**Recommendation Report for Listed Building Consent for Alterations, Extension or Demolition of a
Listed Building**

REF NO: AB/24/22/L

LOCATION: Flat 67 High Street
Arundel
BN18 9AJ

PROPOSAL: Listed building consent to convert the first floor Restaurant into 3 No bedrooms and remove one bedroom on the second floor.

PRACTICE NAME JAMES DOLAN ARCHITECT		
TEL: 07505 996340 Email: james.dolan@ntlworld.com		
PROJECT CHINA PALACE 67 HIGH STREET ARUNDEL		
TITLE SECOND FLOOR BEDROOMS		
PROPOSED PLAN		
SCALE 1.50	DATE FEB 2022	DRAWN BY: JD
DWG No. 67HS/2022/03	REVISION A

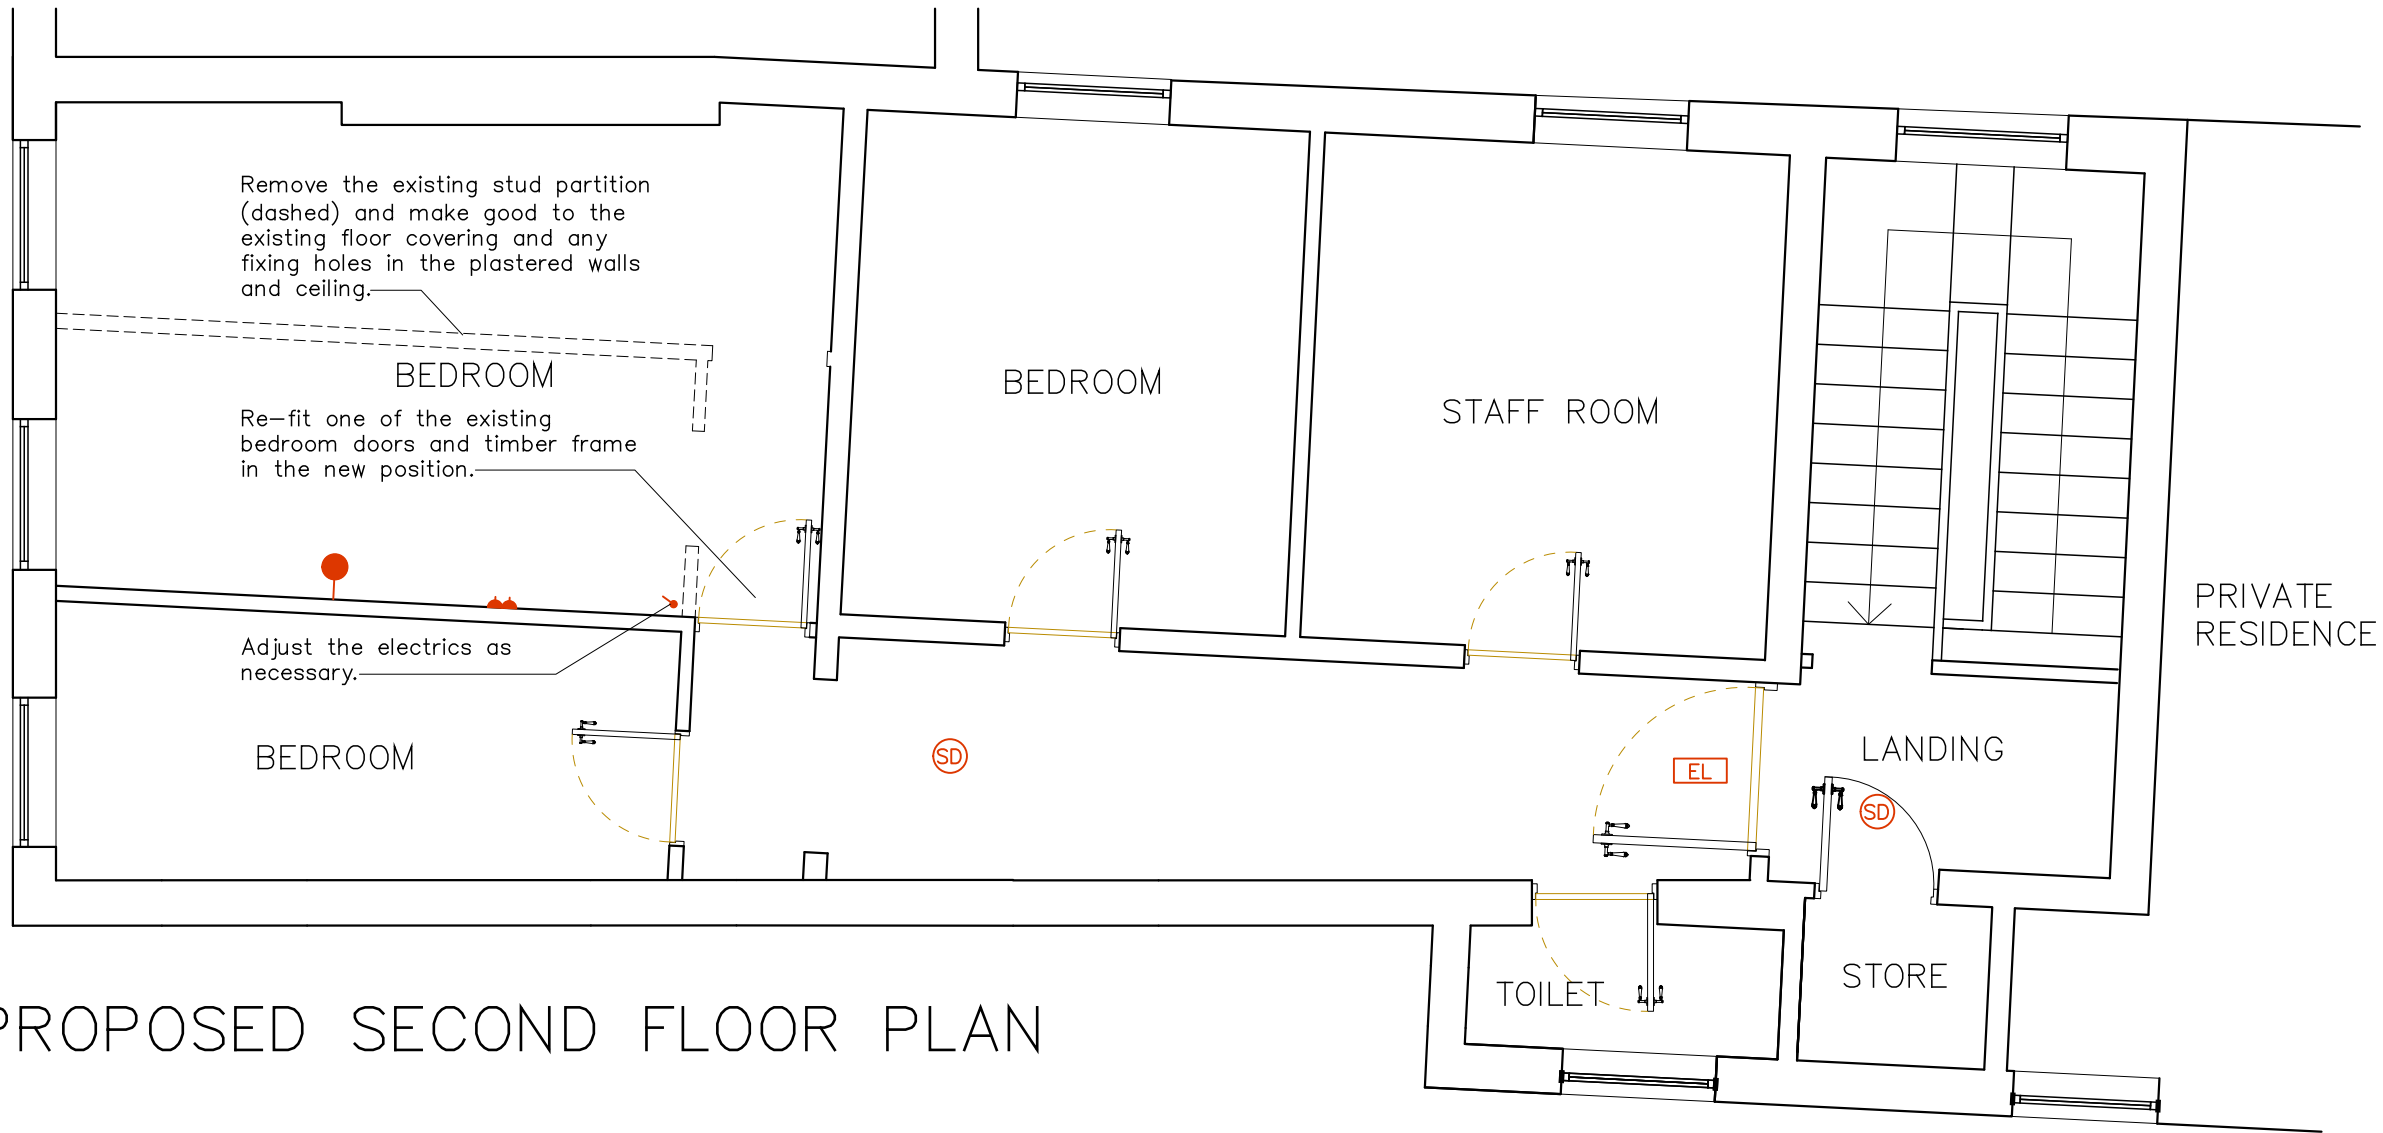
- May not be compliant with building regulations as there does not appear to be any bathroom / washing facilities for habitation purposes.

- The proposed new doors should reflect those found elsewhere in the listed building and further details should be provided regarding them. This can be achieved by way of condition.

Compliance with building regulations is not a planning consideration. This concern may be picked up by building regulations and addressed at a later date.

This report does not consider the impacts of the proposal on the Conservation Area as it is a Listed Building Consent application. Comments noted and recommended condition attached to require submission of details of materials and finishes to be used for new internal doors, so as to ensure they are representative of those already found within the building.

2 Prior to the installation of the new internal doors, details of the design and materials to be used for the new proposed internal doors shall have been submitted to and approved by the Local
